Subject: RE: Planning Consultation on FP/42/19/DOC

Engineers Comments Regarding Condition 7

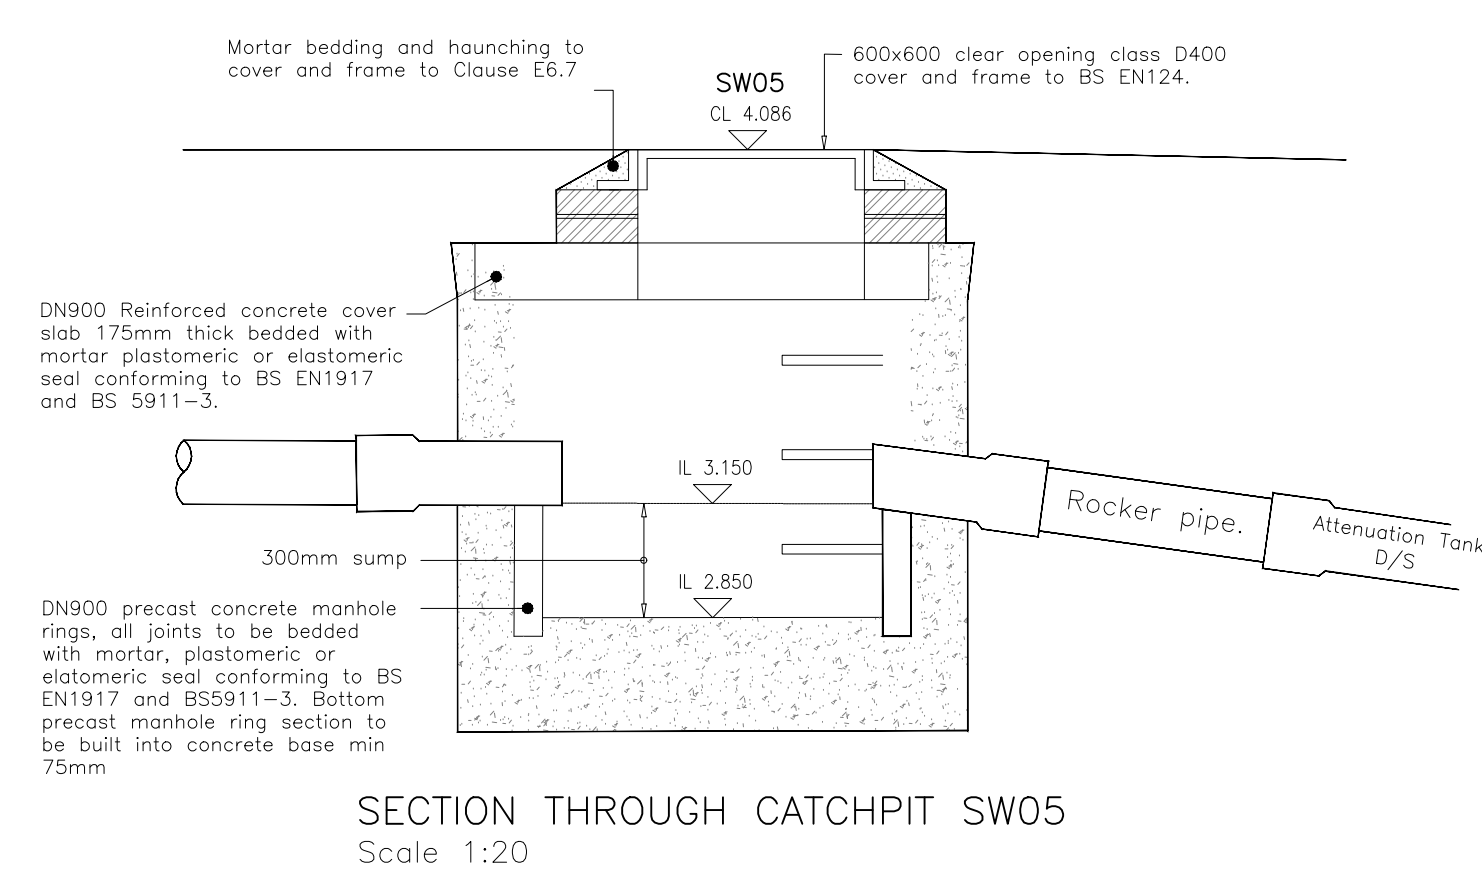
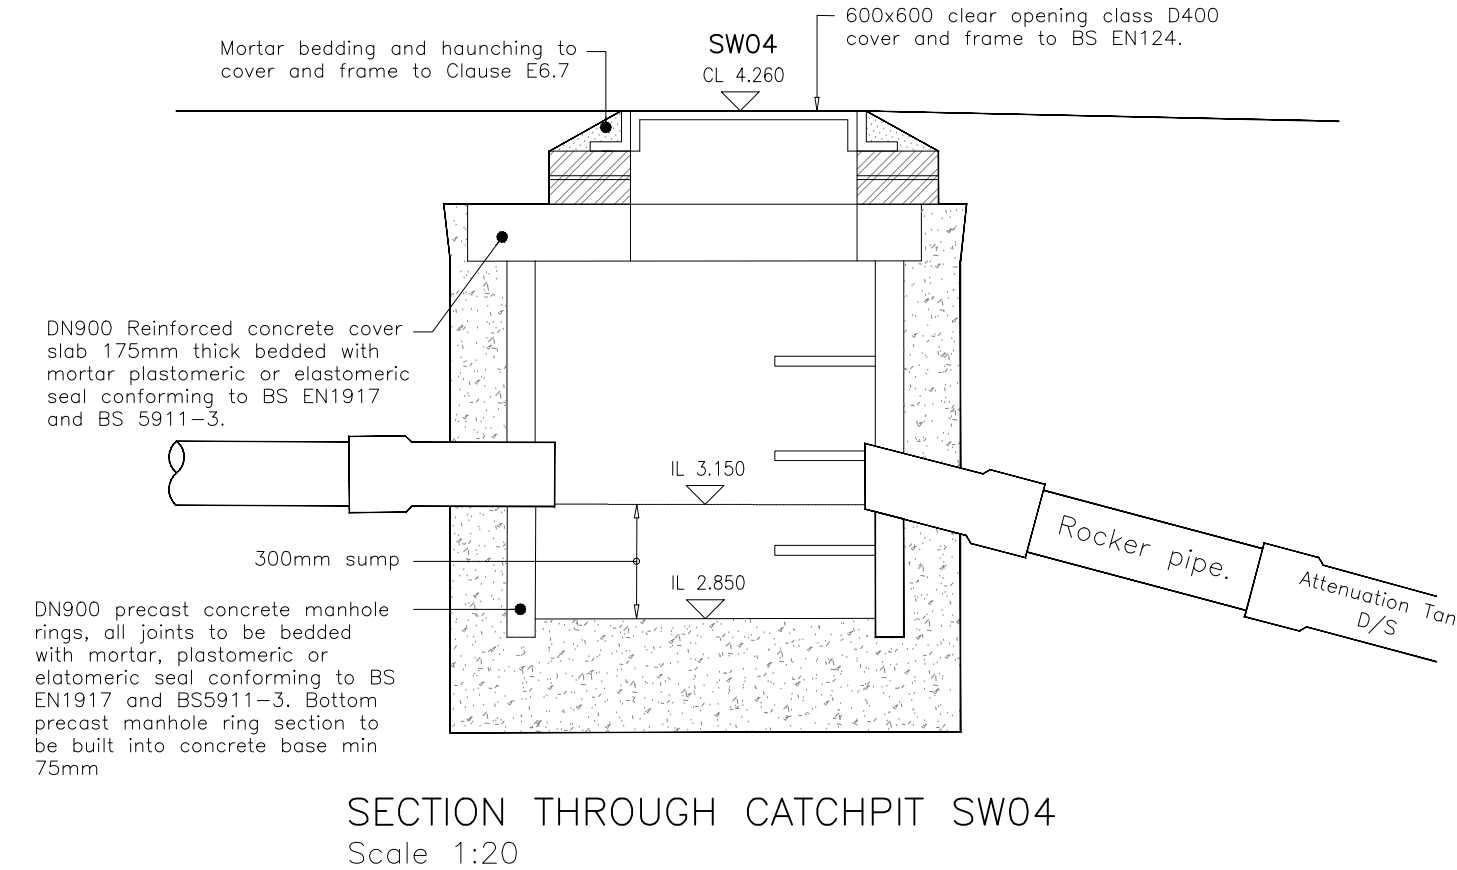
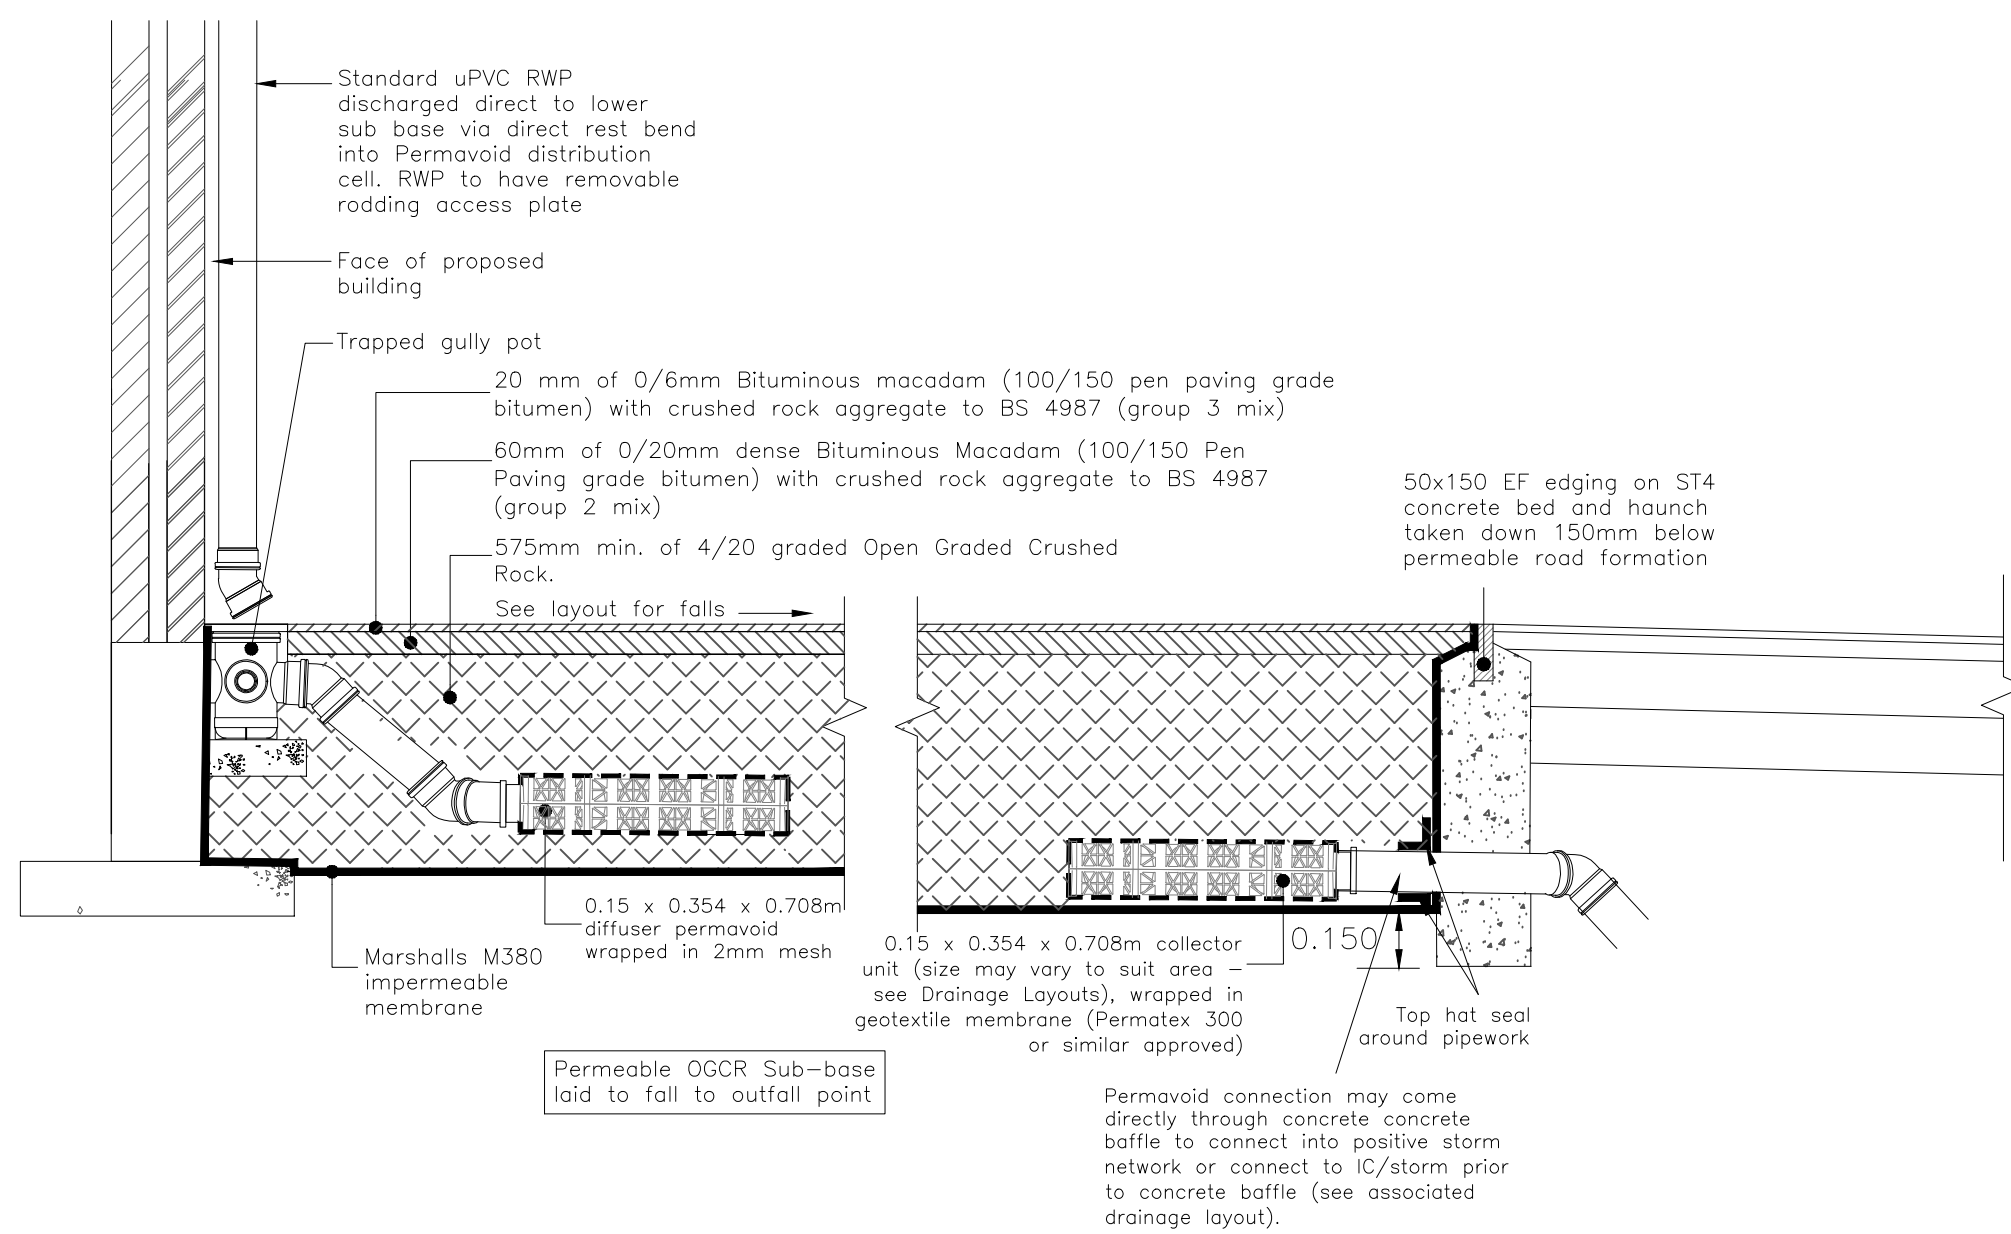
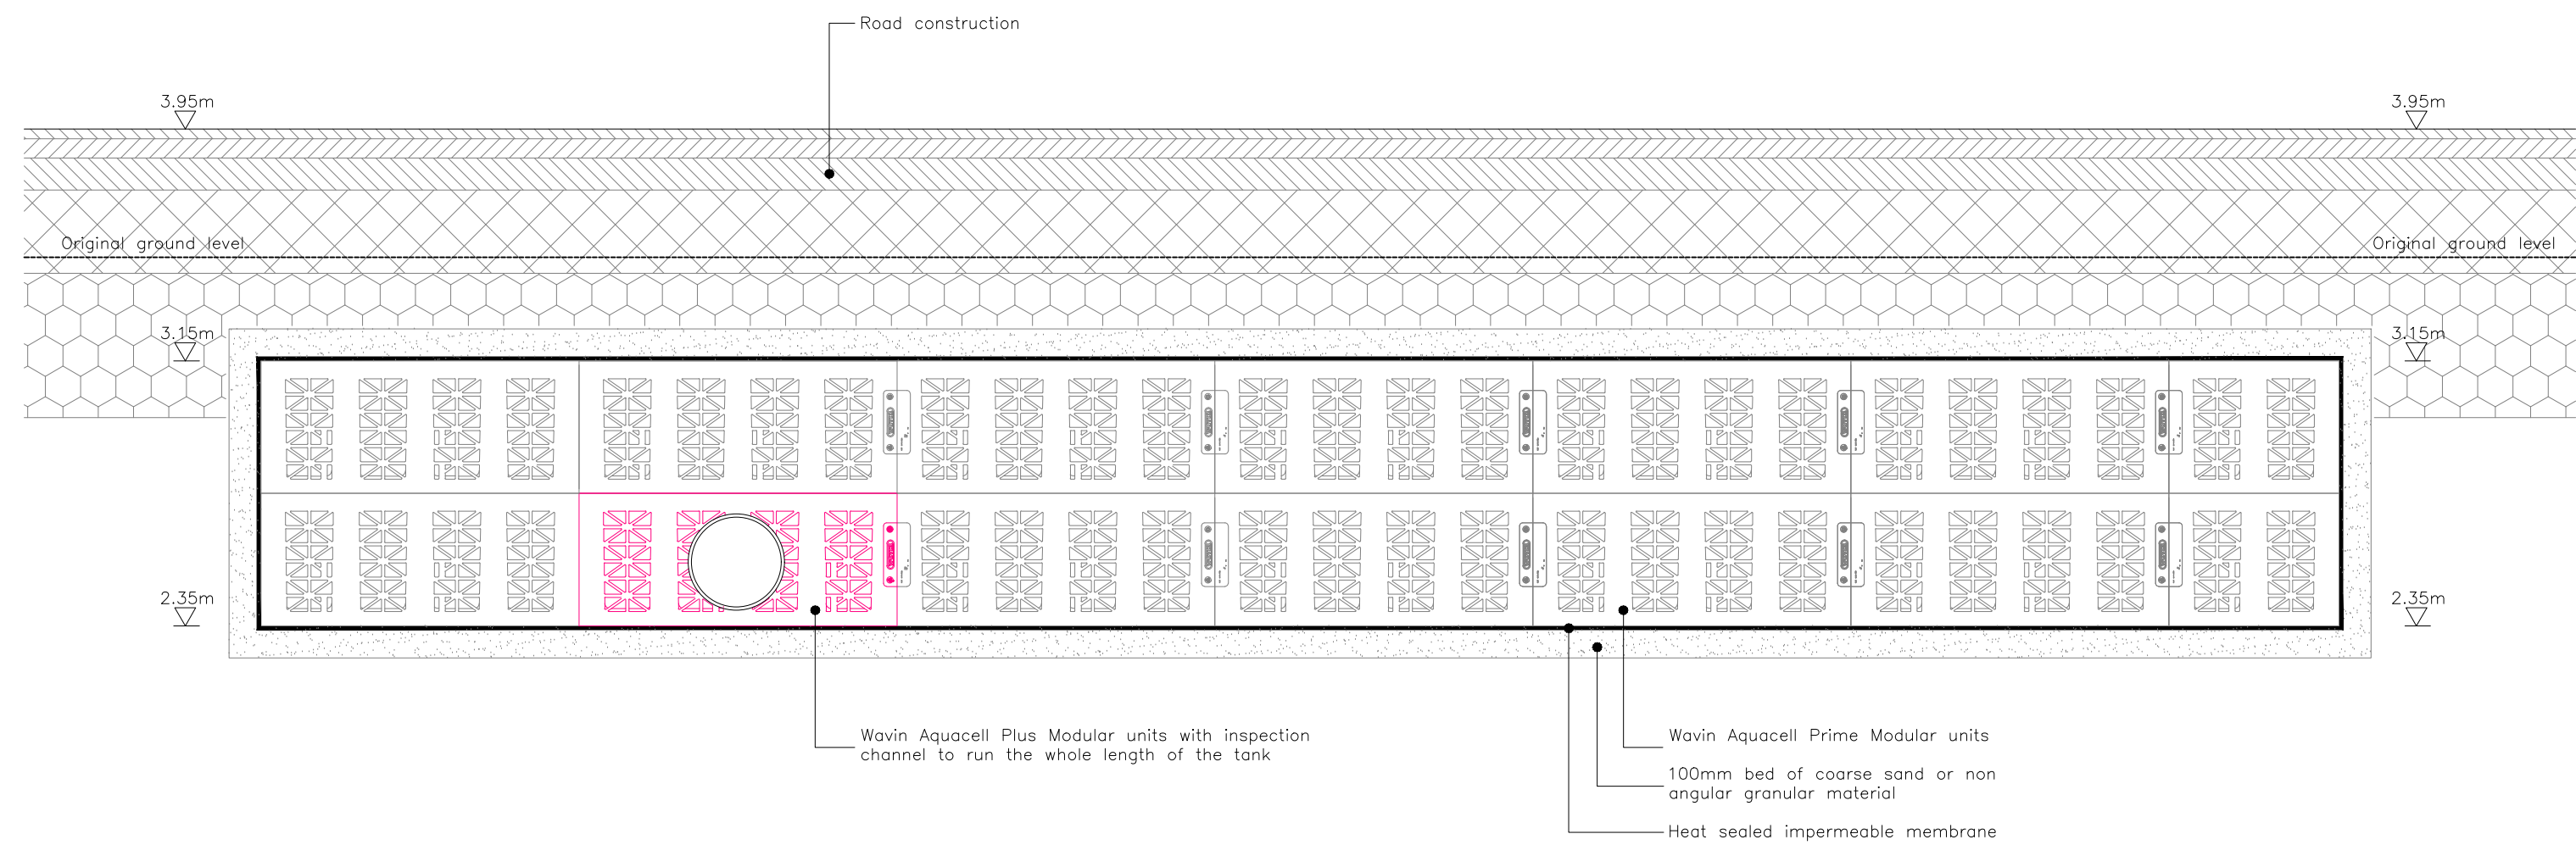
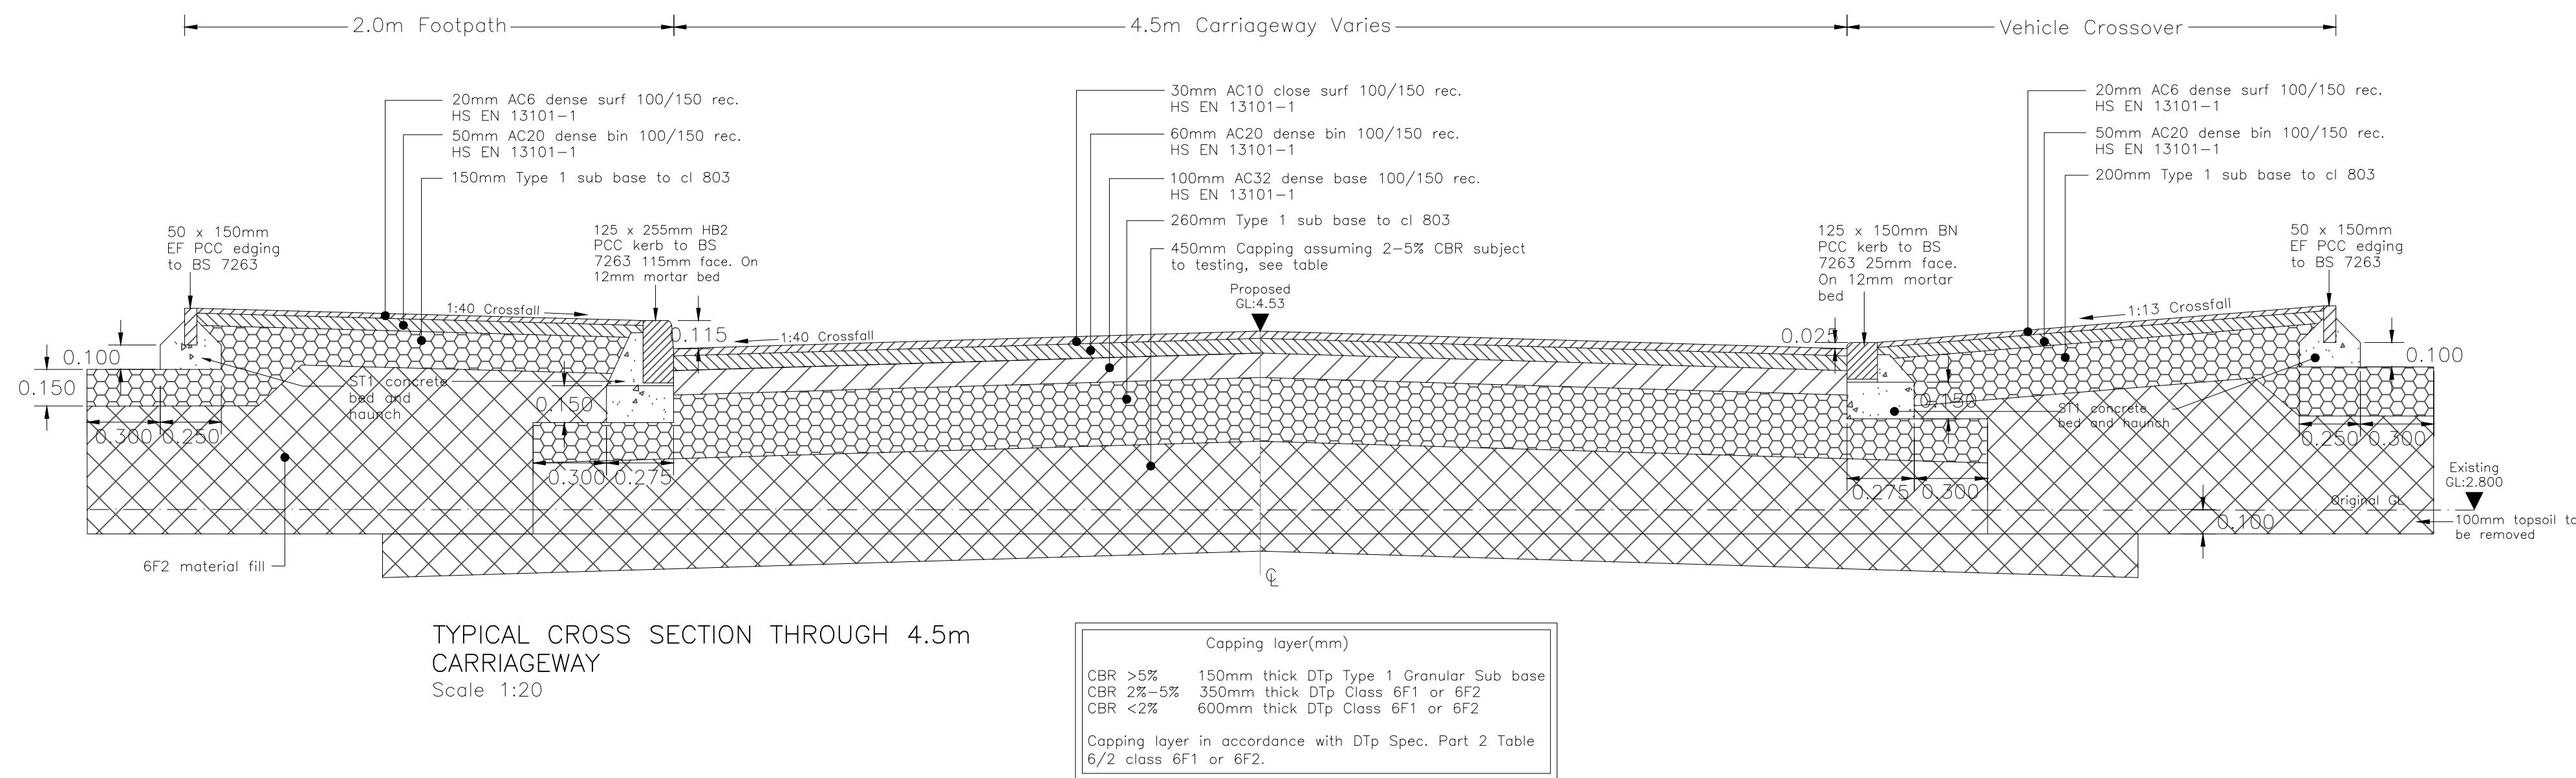
1. The construction detail drawings of the attenuation tanks needs to show the impermeable membrane around the tank, between the tank and the coarse sand bedding.
2. Can the catchpits please be labelled on plan.
3. 3m easement is not being provided to the watercourse at plots 12, 13 and 14. Please can this be provided. Or as a minimum demountable fences provided.
4. Please can the proposed landscaping plans be amended to remove the trees at the end of the parking area between plots 12 and 11/10? Trees are proposed directly in the location of the control chamber and in close proximity to the lined tank.

1. Catchpits must be provided upstream of all connections into the attenuation tank.
Please refer to drawing 5782:23 Construction Details demonstrating manhole SW04 and SW05 should be installed with 300mm deep catchpits.
